# KITTTITAS COUNTY FIRE MARSHAL'S OFFICE

December 9, 2013

Re: Larson Fruit (CU-13-00007)

Upon review of the above mentioned land use action, I have the following comments/requirements;

SITE PLAN

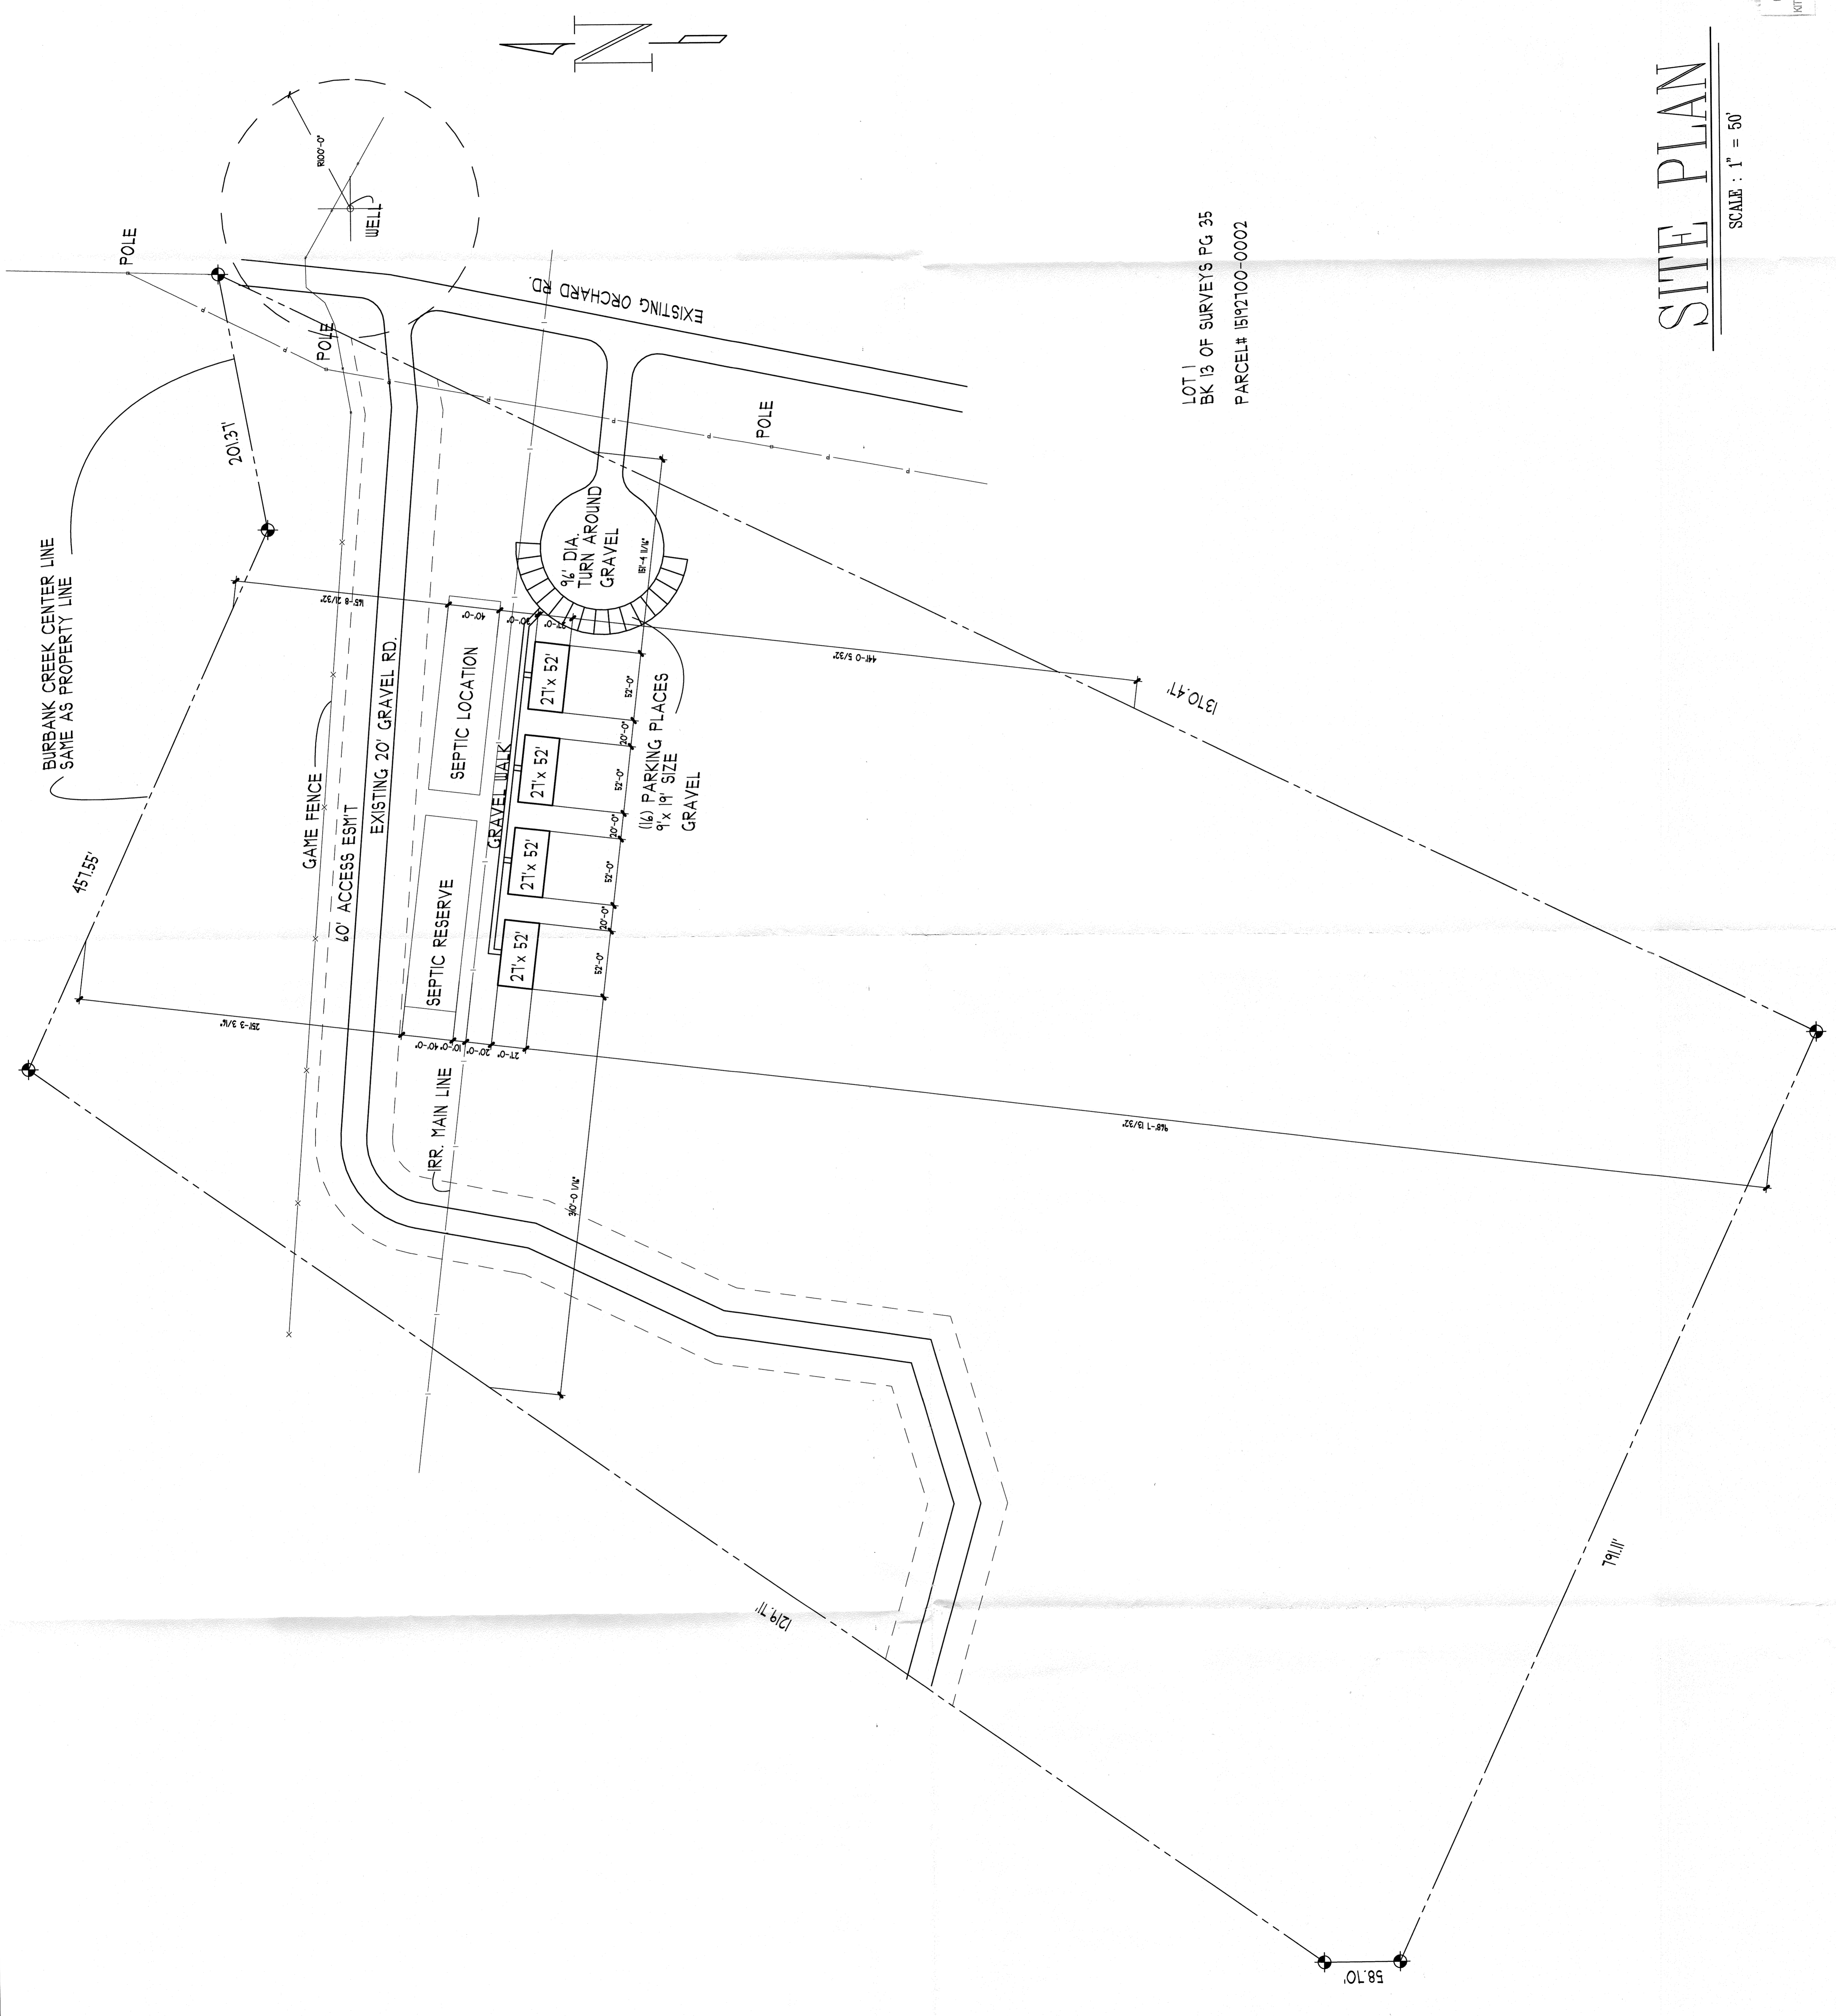
- A turn-around shall be provided for fire department access.
- A County approved blue reflective address marker shall be posted and maintained at the driveway to the structures and on each structure. The individual structures shall be assigned a number or letter by the project manager for emergency purposes, i.e Building 1, Building A, etc.
- The buildings may be no closer than 10' from each other.
- Submittal of a WUI application is required for this property as it is located outside of a fire district.
- Fire extinguishers shall be located appropriately. I can assist with this prior to occupancy.
- A fire and life safety inspection shall be conducted prior to occupancy.
- All development, design and construction shall comply with Kittitas County Code, Kittitas County Zoning and the most current version of the International Fire & Building Codes.
